KIRKLEES METROPOLITAN COUNCIL INVESTMENT & REGENERATION SERVICE

DELEGATED DECISION TO DETERMINE PLANNING APPLICATIONS

Reference No:	2025/62/90099/W
Site Address:	7, Bradley Grange Gardens, Bradley, Huddersfield, HD2 1QX
Description:	Erection of single and two storey extensions to the side, front and rear and formation of extended access including associated works
Recommending Officer:	Molly Storer

Officer Report.

Title: PROPOSED REVISED LAYOUT.

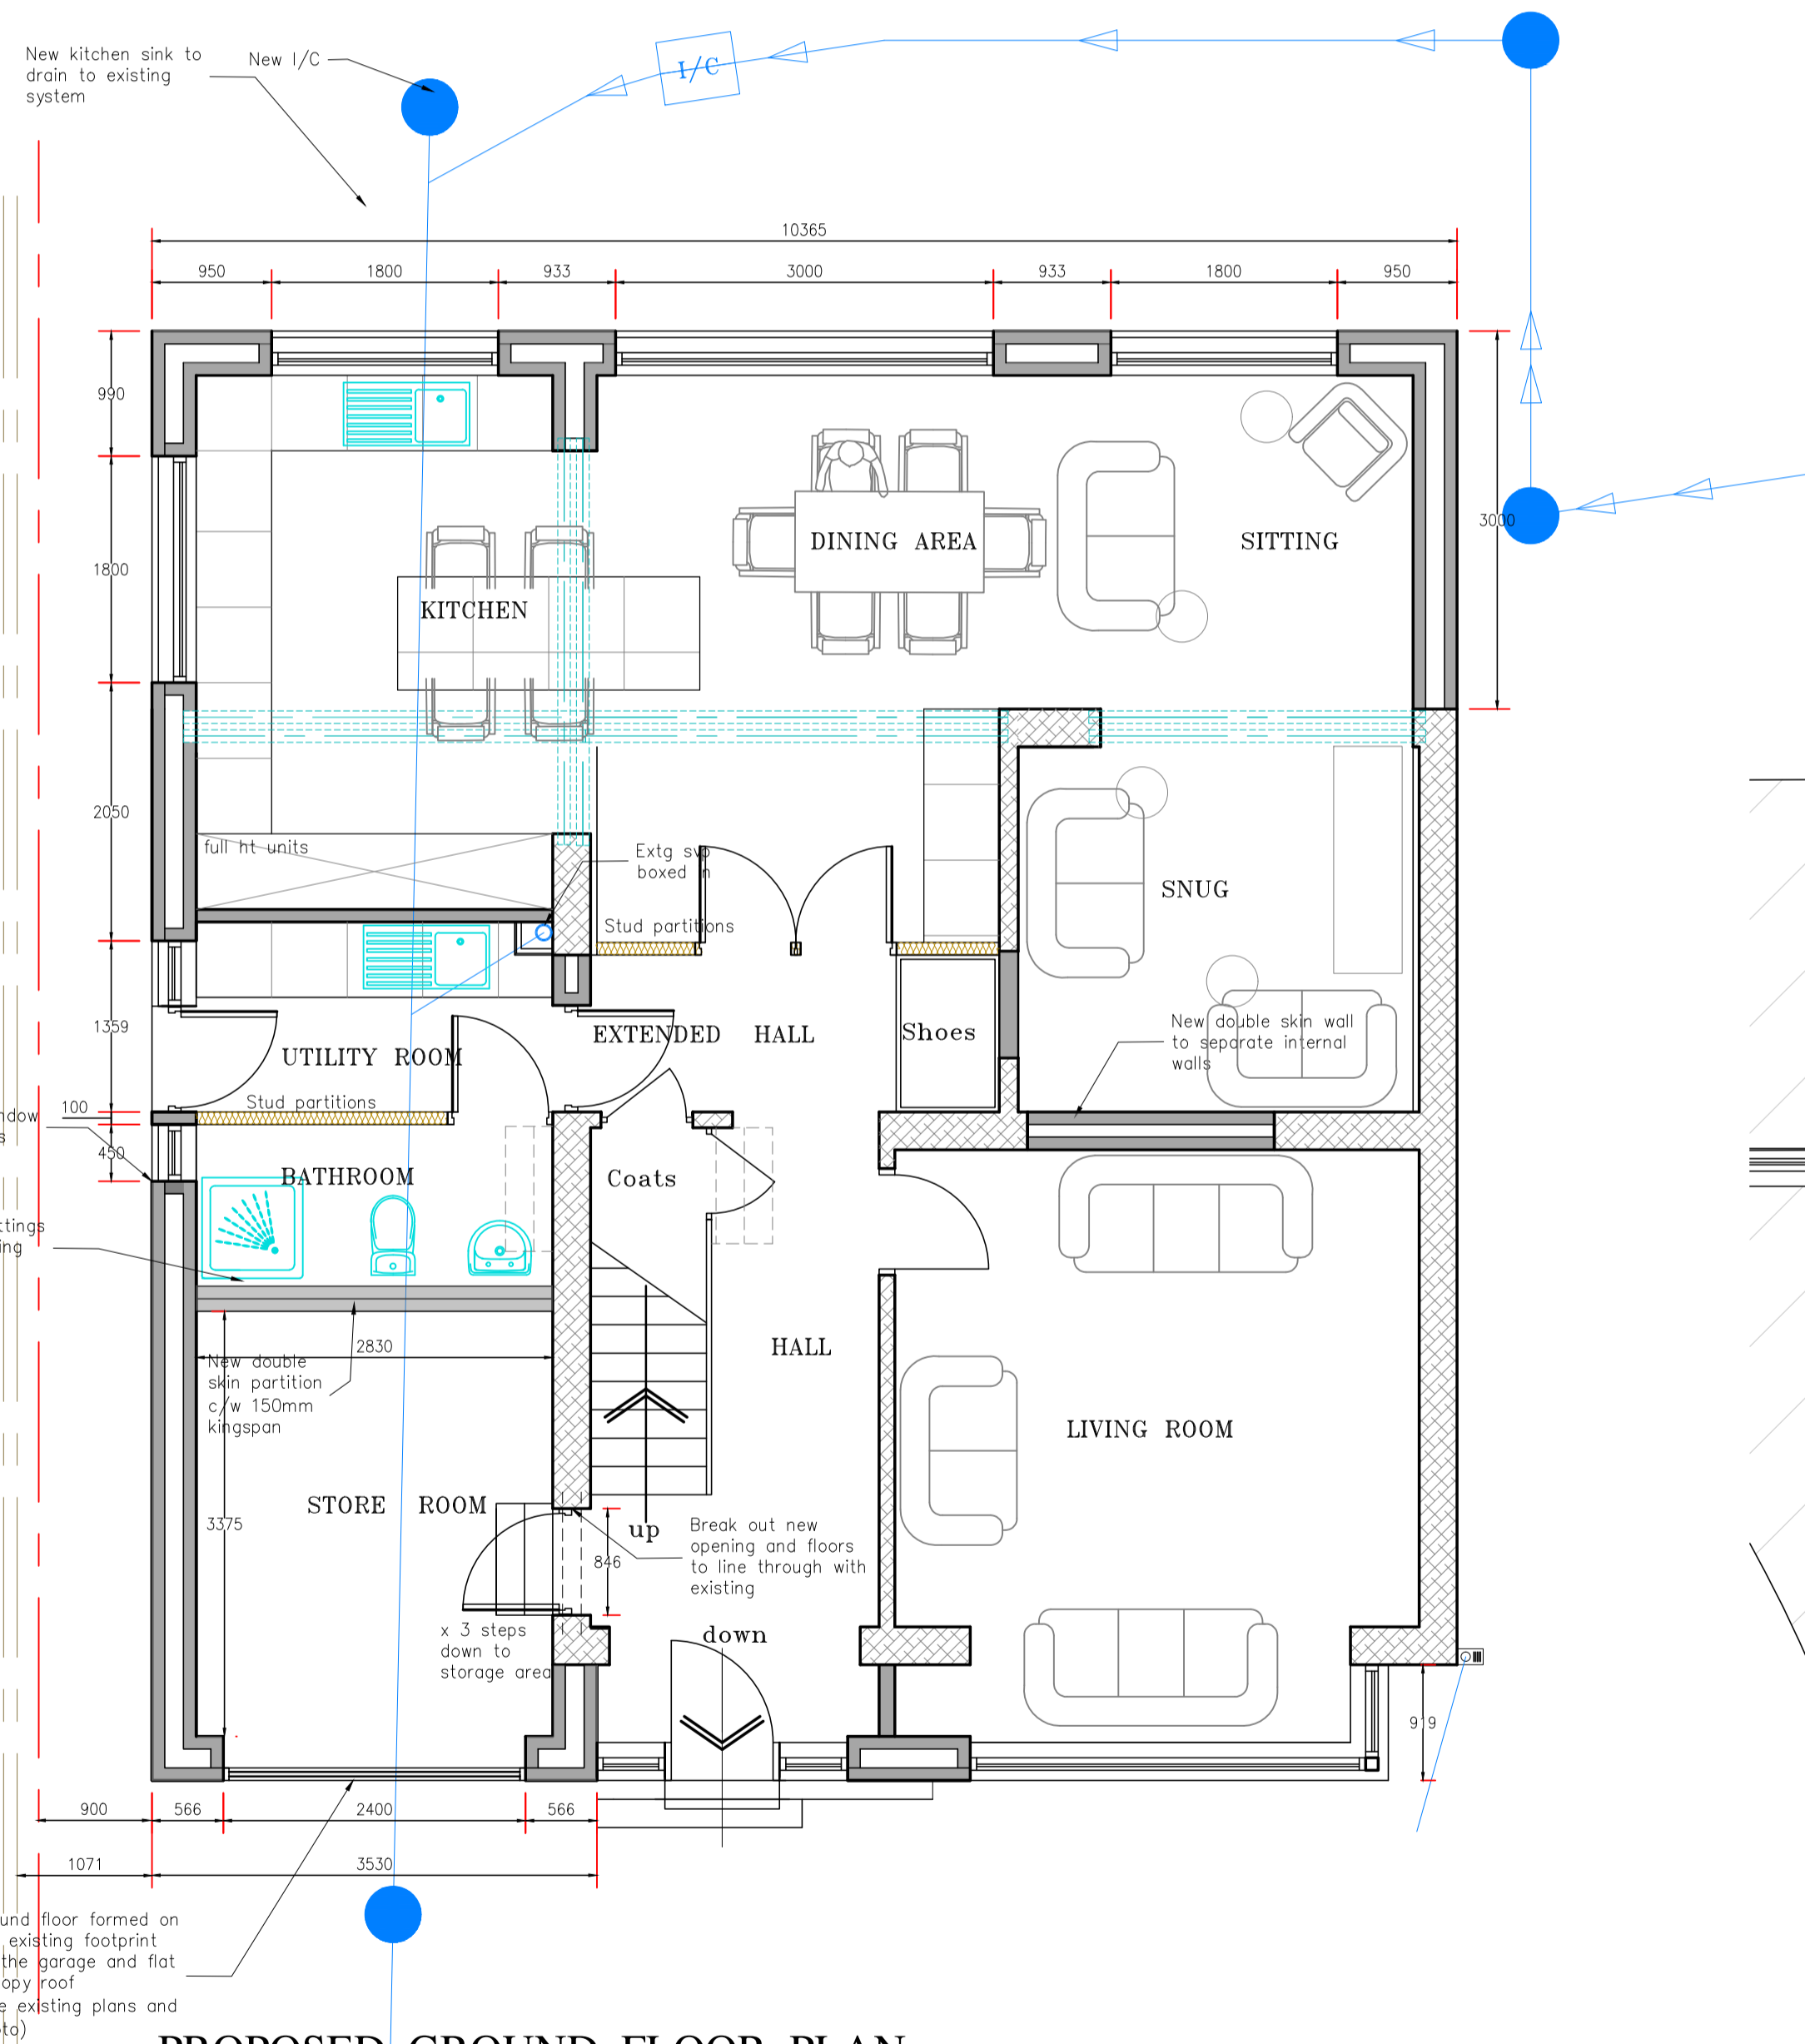
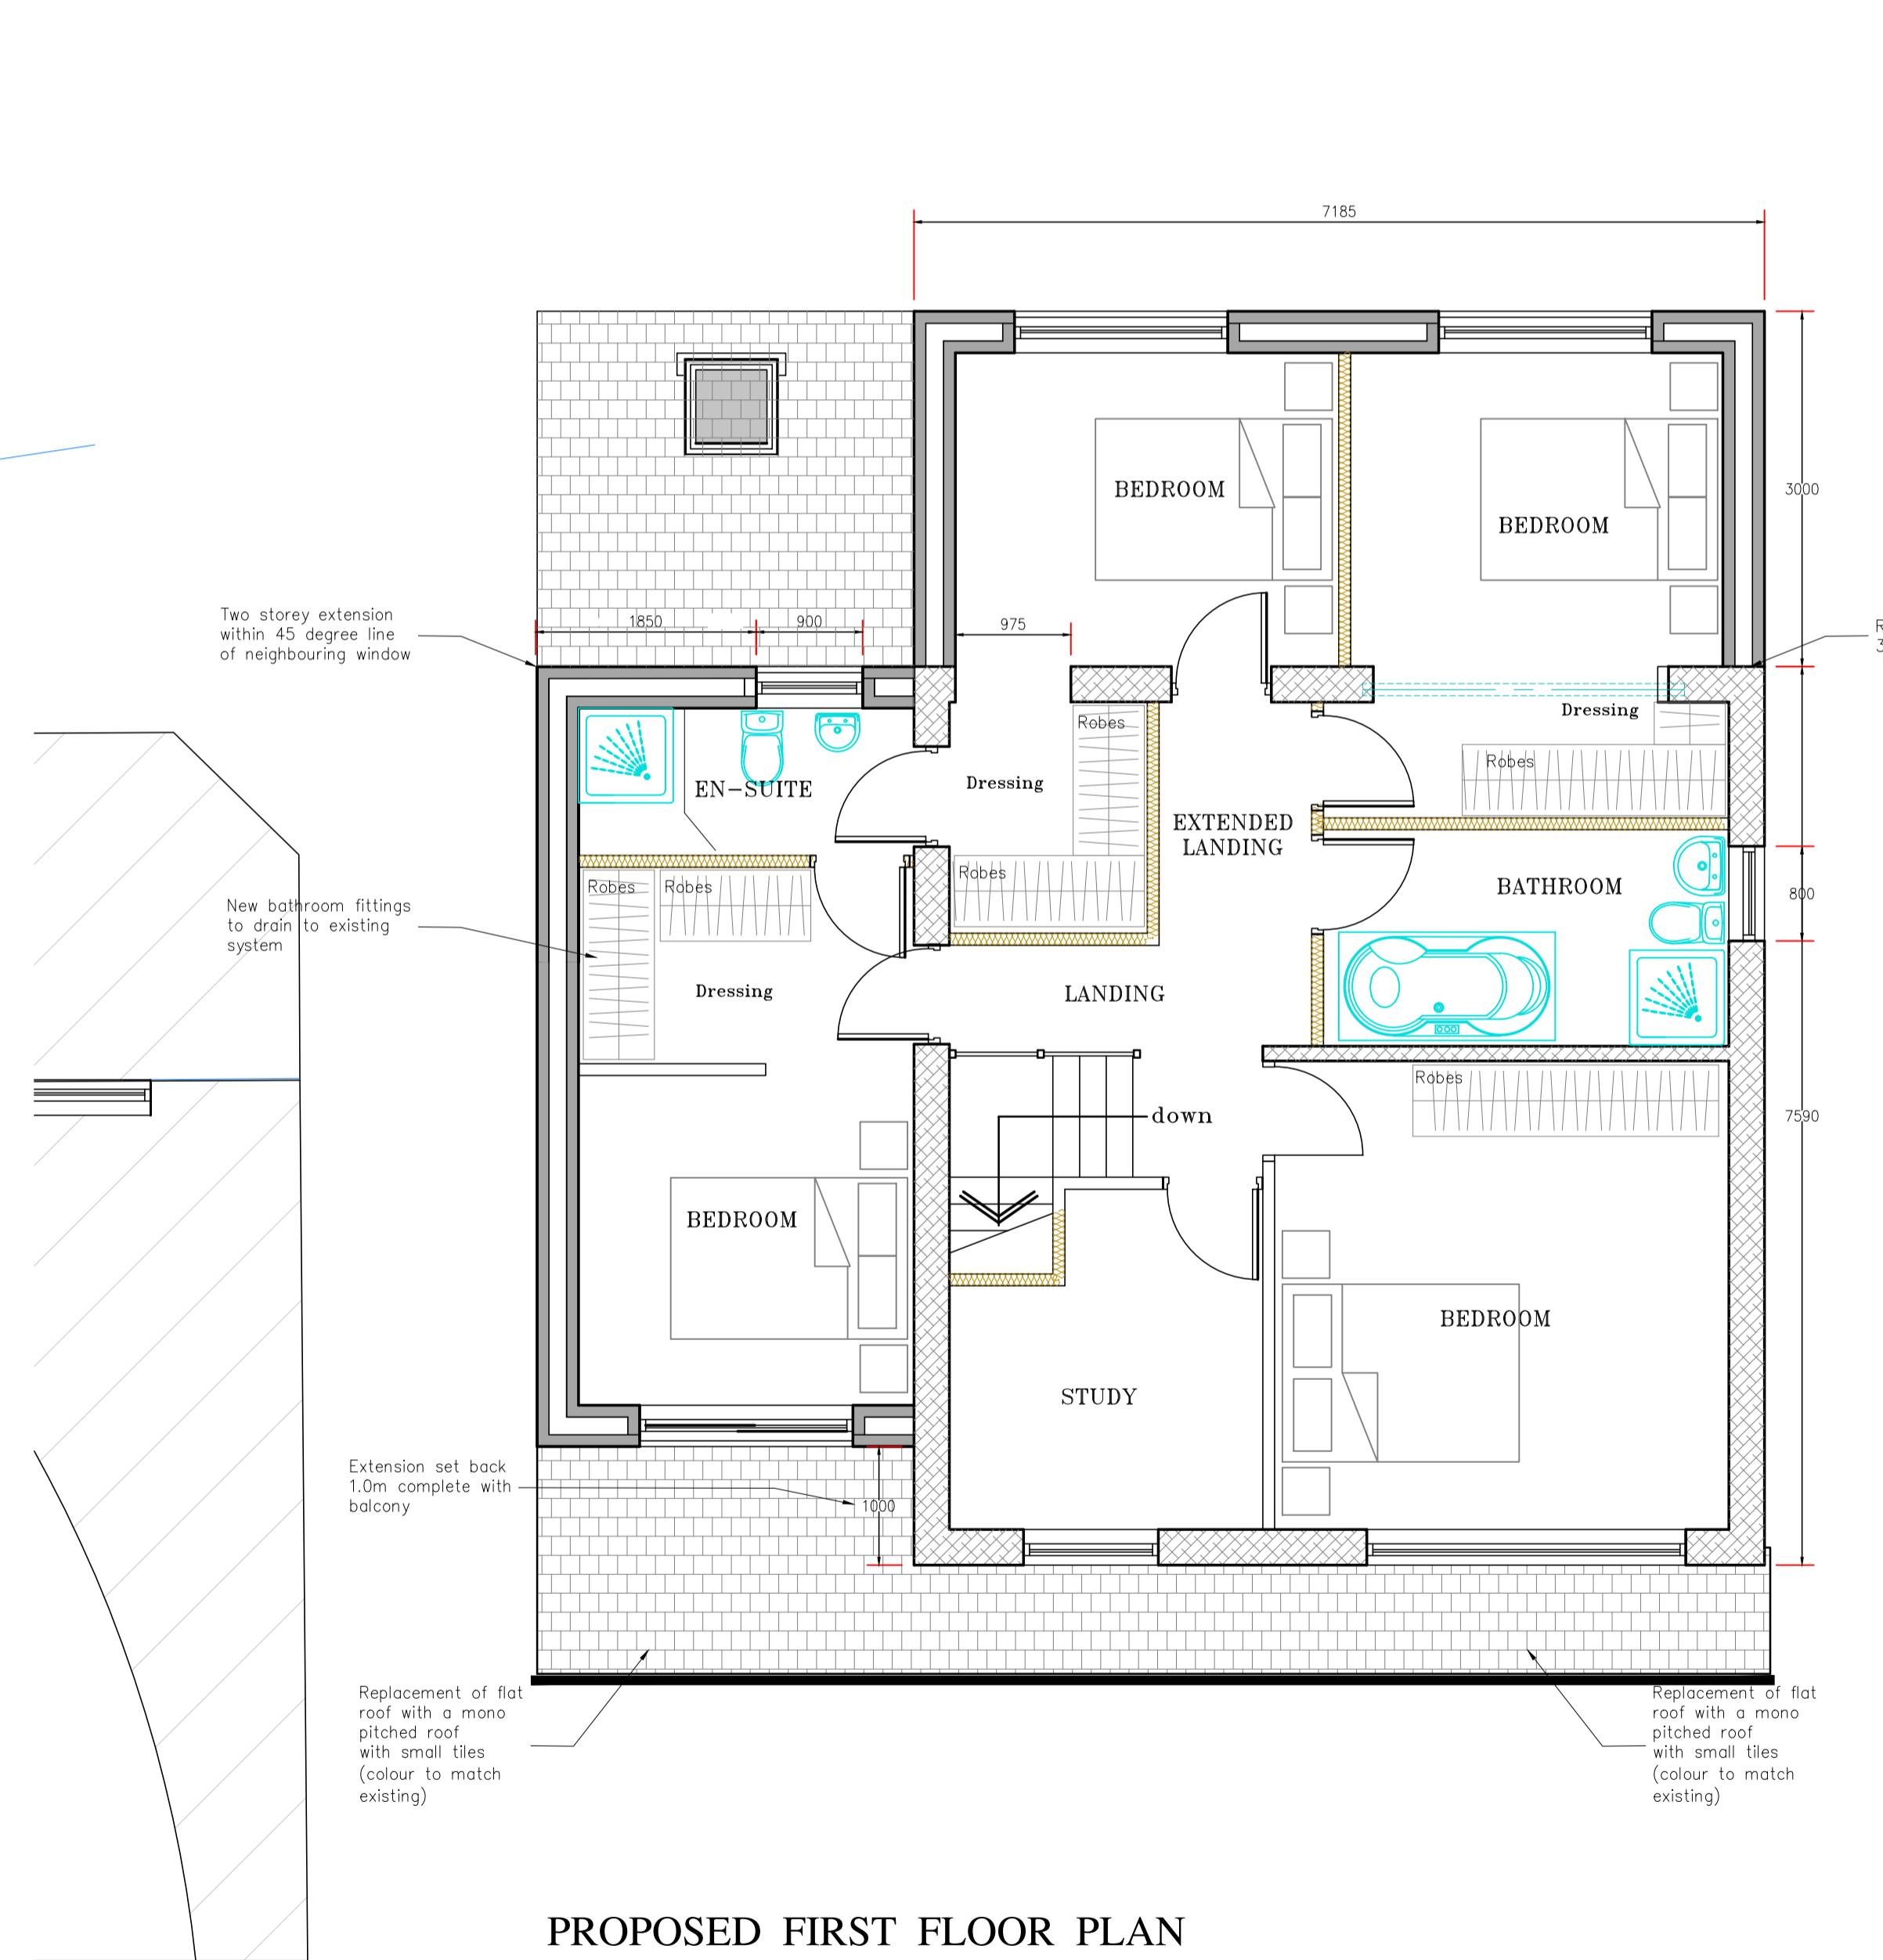
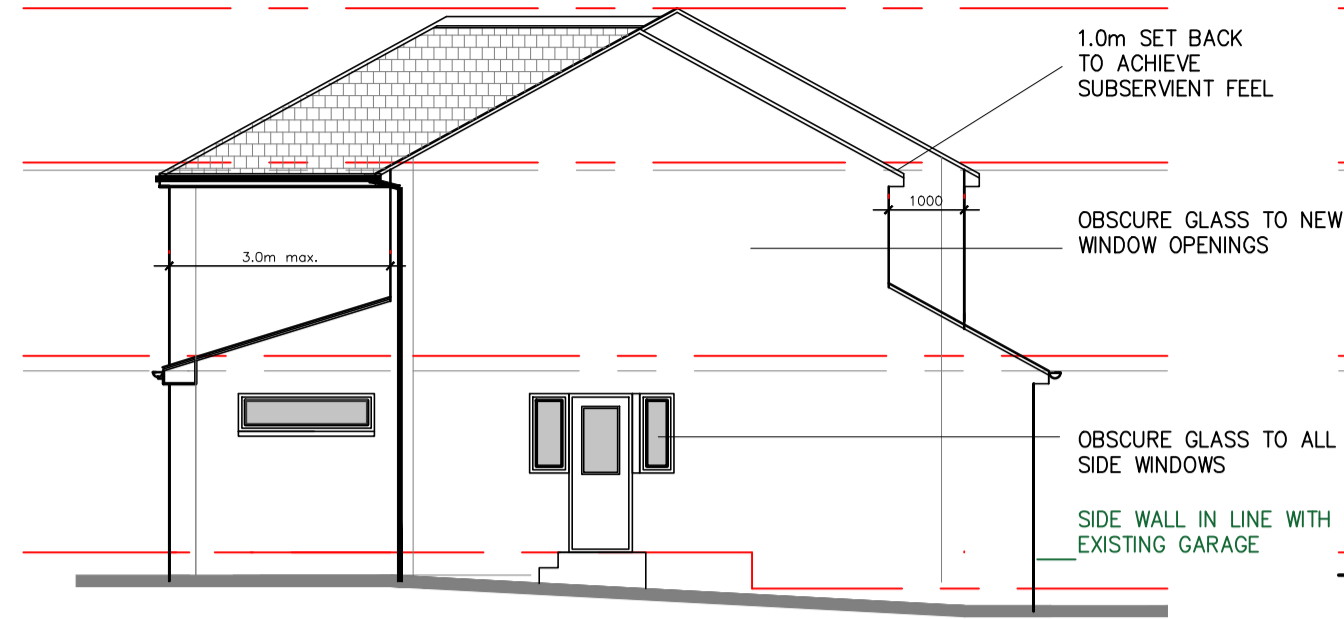
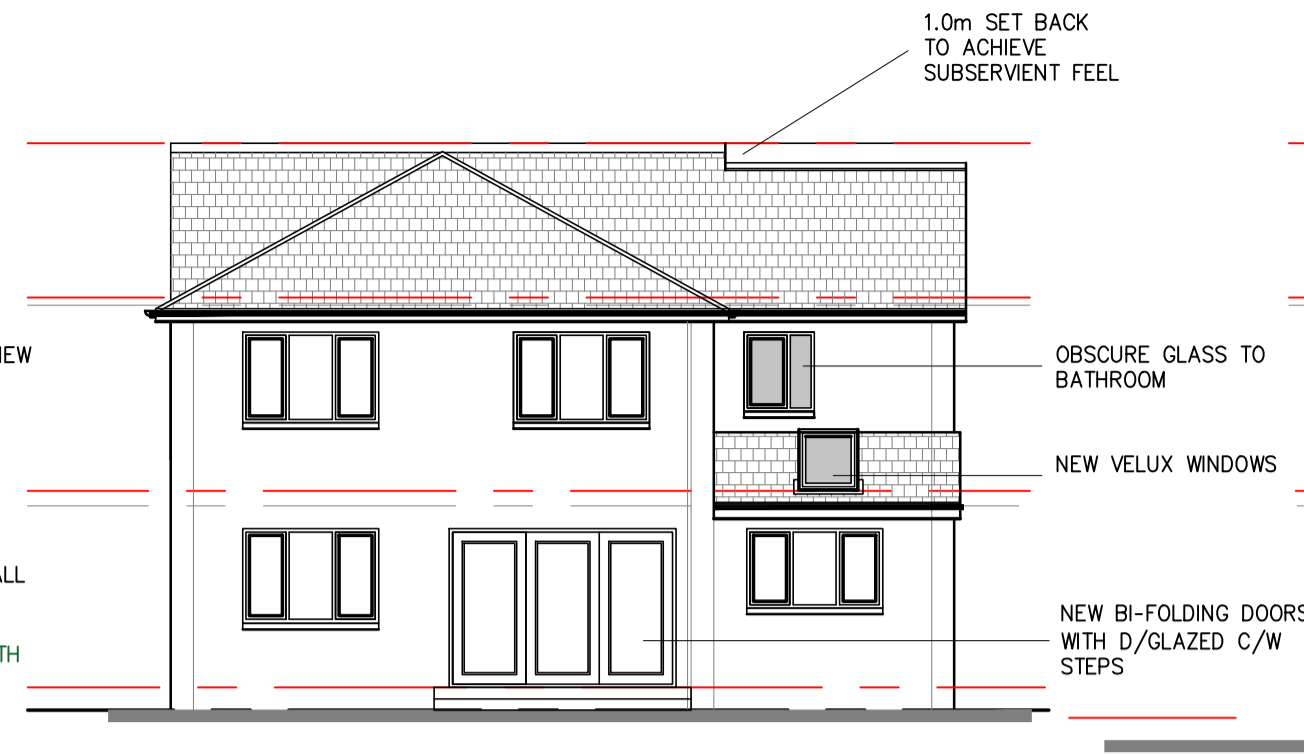
Whilst it is noted that the footprint of the dwelling would significantly increase, these additions are now predominantly to the side and rear. The amended plans show the first floor front element removed and the first floor element of the side extension set back behind the front elevation. This means that the two storey side extension will now comply with the SPD as the first floor element is set back by 1m and set down from the roof ridge of the existing house. It is also set in from the side boundary by 1m.

The design would still see a single storey front element and the single storey side element would extend to align with this. However, this design has overcome previous reasons for refusal as it is now limited to single storey and would not extend beyond the existing canopy to the front. It would also be in-line with the existing bay window to the front of the property. Therefore, although front extensions are usually not acceptable, on balance it is considered in this instance that the front element is now of a design which is subservient to the original dwelling would not harm the character of the wider street scene.

The two storey rear extension would still only maintain a gap of 1m to the boundary with No.9 but has been reduced in size from the previous refusals. It would not only project from the rear wall by 3m but would be set down by 0.5m with a hipped roof. Therefore, although it does not comply strictly with the SPD, it will not extend further than the rear at number 9 where it is within 1.5m of the boundary and where it extends further to the rear than number 7, the two storey rear element is at a separation distance of over 4m.

In addition, officer's note that the majority of the proposed two-storey side extension would sit adjacent to the solid side elevation of No. 5. Whilst a length of approximately 3.85 metres of the two-storey side extension would project beyond the brick rear elevation of No. 5, it would retain a separation distance of 2.6 metres from the siting of the conservatory to the rear of this neighbouring property and would not cut a line of 45-degrees across the glazing which serves the conservatory, or the closest first floor windows. Therefore, for these reasons, it is not considered that the proposed two-storey side extension would result in undue impacts of overbearing or overshadowing towards No. 5.

With regards to the rear elements, the design has been reduced from the previous refusal from 4m to 3m. Although the single storey lean-to rear extension would not be compliant with the 45-degree rule, as set out under Key Design Principle 5 of the House Extensions and Alterations SPD, it is noted that the single storey rear element will have a limited projection, eaves and overall height. Furthermore, the two storey rear extension now is of a hipped roof design to further limit overall bulk and massing to this neighbour.

The proposal includes some glazing to face directly towards No. 5 Bradley Grange Gardens. This to serve bathrooms, a utility room and the kitchen. Upon any grant of approval, a condition is recommended to be imposed to obscure glaze all these windows to the side elevation, for reasons of protecting residential privacy and mitigate undue levels of overlooking.

The proposed two-storey rear extension would be separated from the shared boundary with No. 9 by approximately 1m and due to the reduction in projection from the previous proposal the rear extension would not project beyond the rear elevation of No.9.

It is also noted that the proposed two-storey extension would not cut a line of 45-degrees to any habitable room windows to the rear of No. 9 and would not extend towards the patio area which serves No. 9, considered to be a primary area of functional outdoor amenity space to serve the occupiers of No. 9. This means that there would be no significant overdue overshadowing/overbearing impact to this property.

The only glazing proposed to the side elevation of the dwelling adjacent to No. 9 is a bathroom window. This would therefore likely be obscure glazed and as such, would not impact upon residential privacy with regard to overlooking. To ensure appropriate levels of residential amenity would be achieved, upon any grant of permission, a condition is recommended to be imposed to ensure this window be obscure glazed and non-opening.

3. All windows within the west side elevation facing No.5 Bradley Grange Gardens upon submitted plan titled 'proposed revised layout' (ref: PDA23-069-004 Rev E) shall be obscurely glazed and be non-opening.

4. All windows within the east side elevation facing No.9 Bradley Grange Gardens upon submitted plan titled 'proposed revised layout' (ref: PDA23-069-004 Rev E) shall be obscurely glazed and be non-opening.
